Re: Princeton Townhomes
317 Princeton SE
Traffic Circulation Layout
Engineer's/Architect's Stamp None provided (K16-D093)

Based upon the information provided in your submittal received 03-16-2022, the above referenced plan cannot be approved for Building Permit until the following comments are addressed:

Project	Sheet
Date 3/15/2022	TCL
Scale As Noted

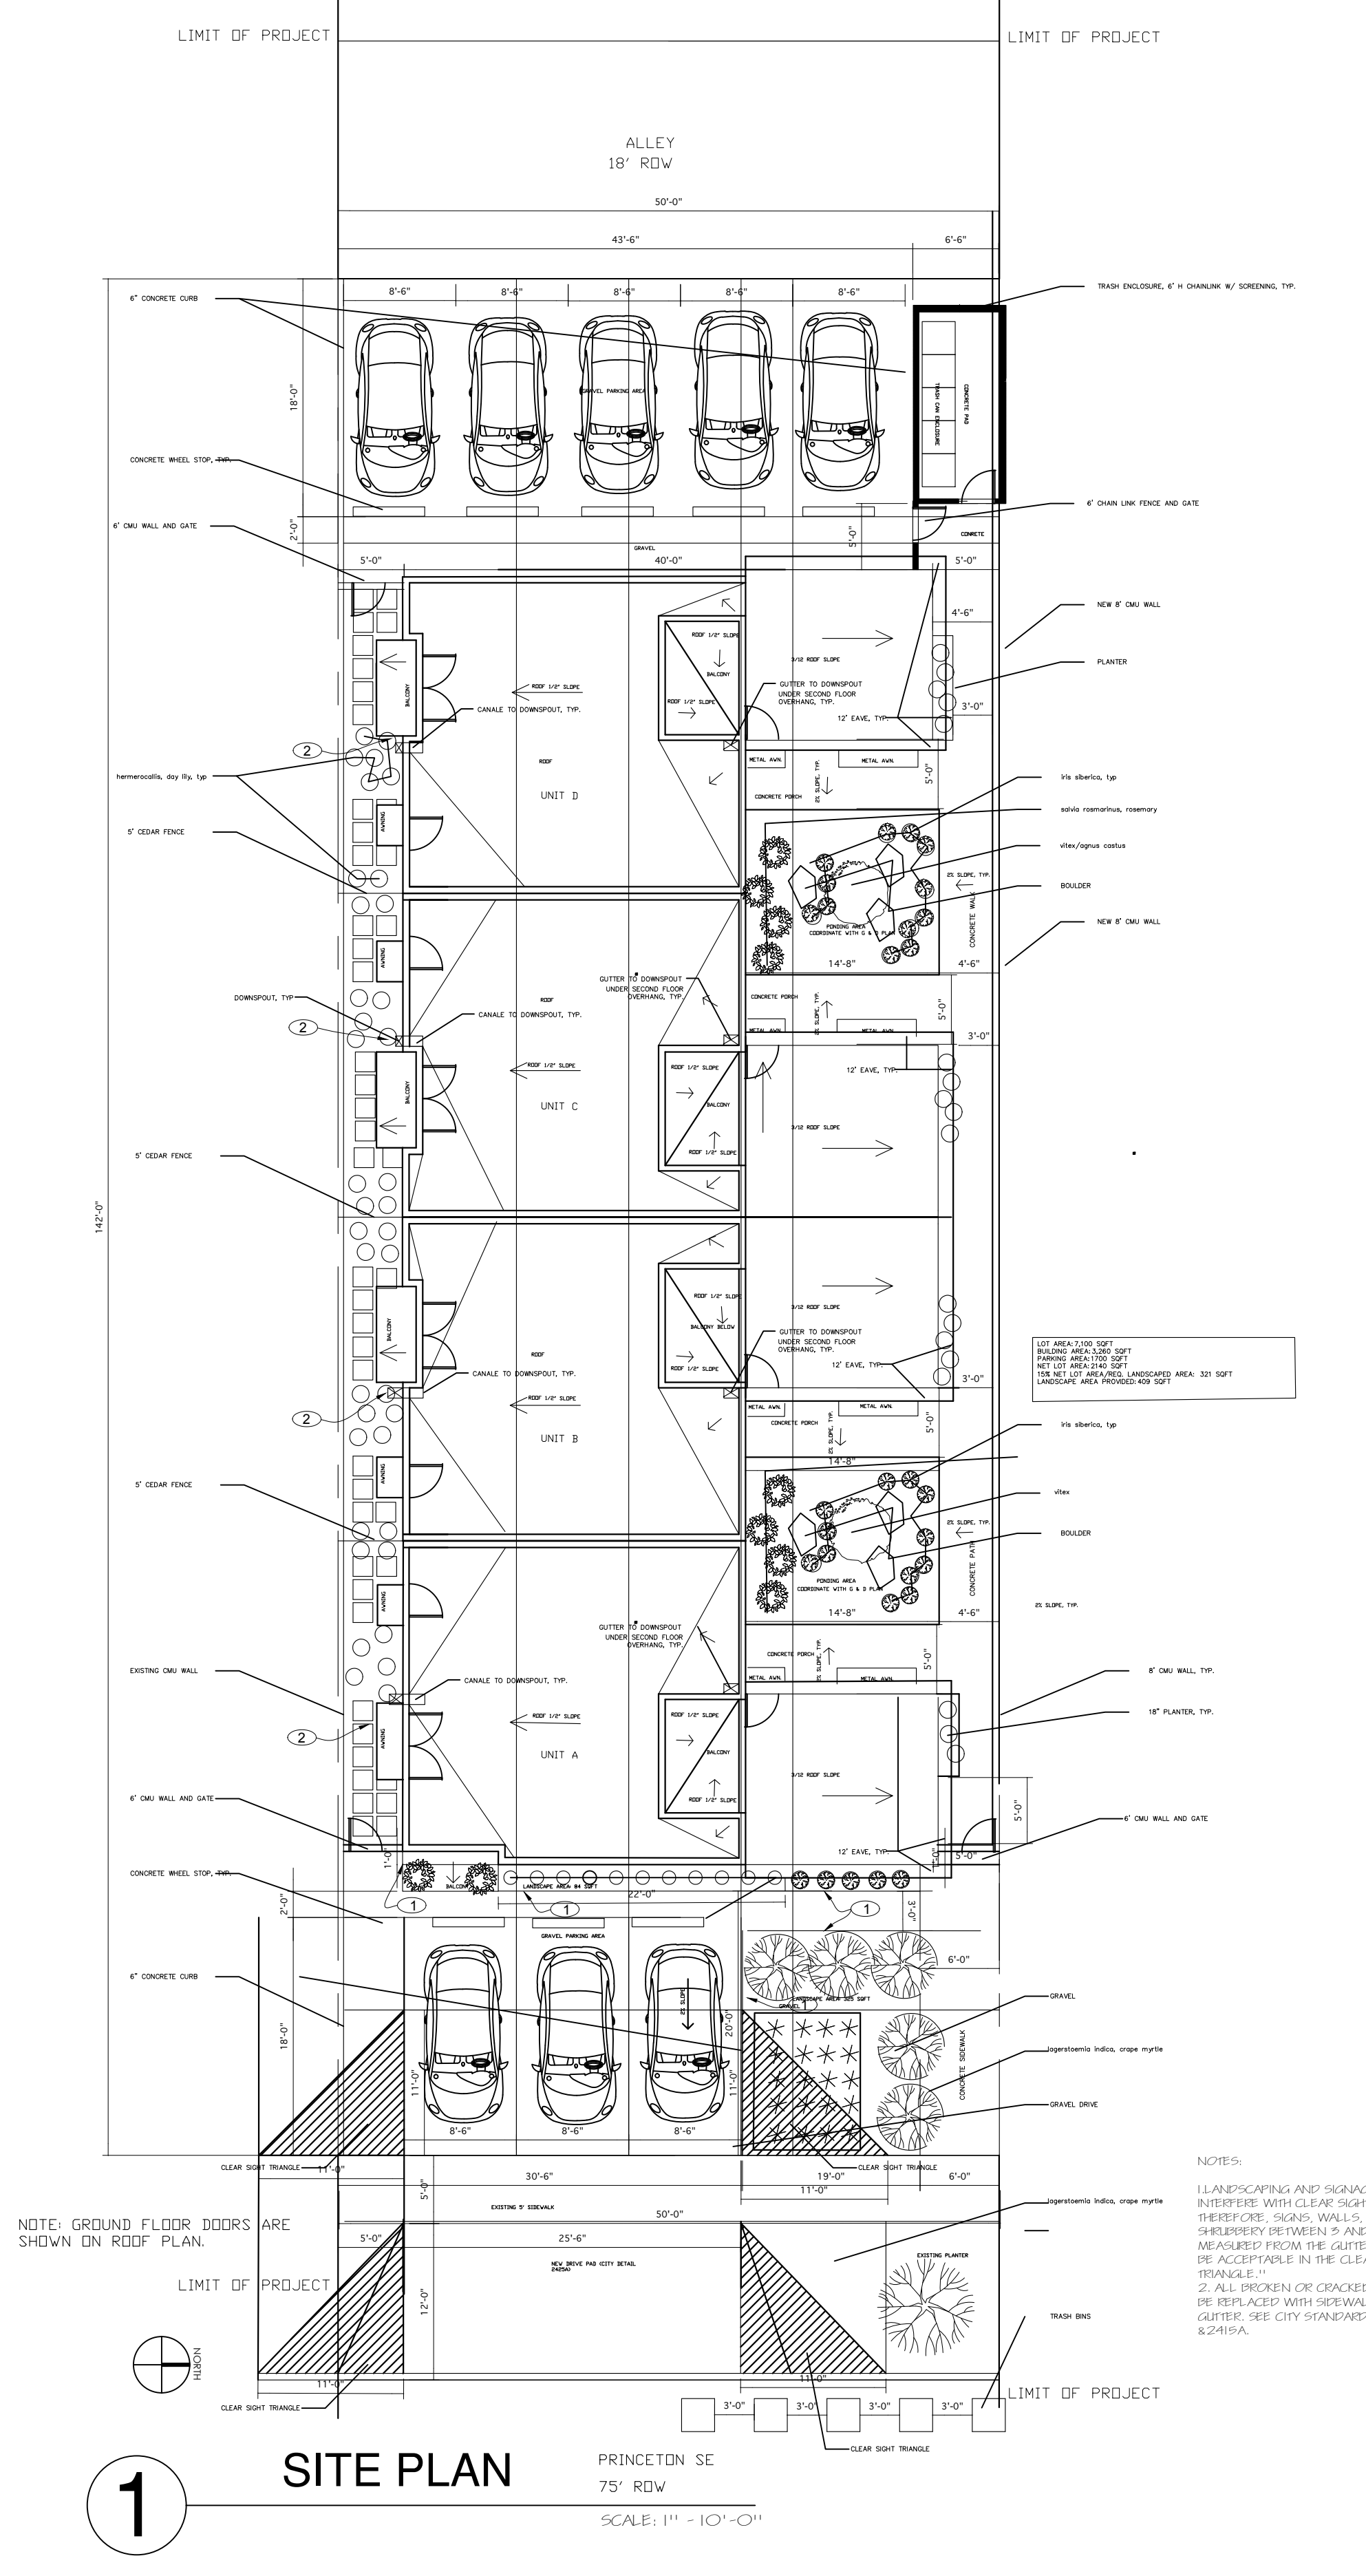
1. The traffic circulation layout must be stamped, signed, and dated by an engineer or architect licensed in the state of New Mexico.
2. Please provide the offset from edge of gravel parking stalls to Alley way.

3. Proposed Trash Can Enclosure: Please explain how you will traverse trash bins from the location of enclosure to the front for trash/solid waster pickup.

4. Please provide a sight distance exhibit (for Princeton frontage proposed landscaping at drivepad per DPM requirements).
5. Show the clear sight triangle and add the following note to the plan: "Landscaping and signage will not interfere with clear sight requirements. Therefore, signs, walls, trees, and shrubbery between 3 and 8 feet tall (as measured from the gutter pan) will not be acceptable in the clear sight triangle.

6. Please specify the City Standard Drawing Number when applicable.
7. Princeton Frontage:
 - Shown is a 25'-^' drivepad. Is this existing or proposed. If proposed provide detail for a new drivepad.

- Sidewalk existing: provide width.
8. A detail will be needed for the following proposed items:
 - Concrete wheel stop.
 - 6" concrete curb.
 - 6 ft sidewalk.

9. Add a note stating "All broken or cracked sidewalk must be replaced with sidewalk and curb & gutter." A build note must be provided referring to the appropriate City Standard drawing (2430 & 2415A).
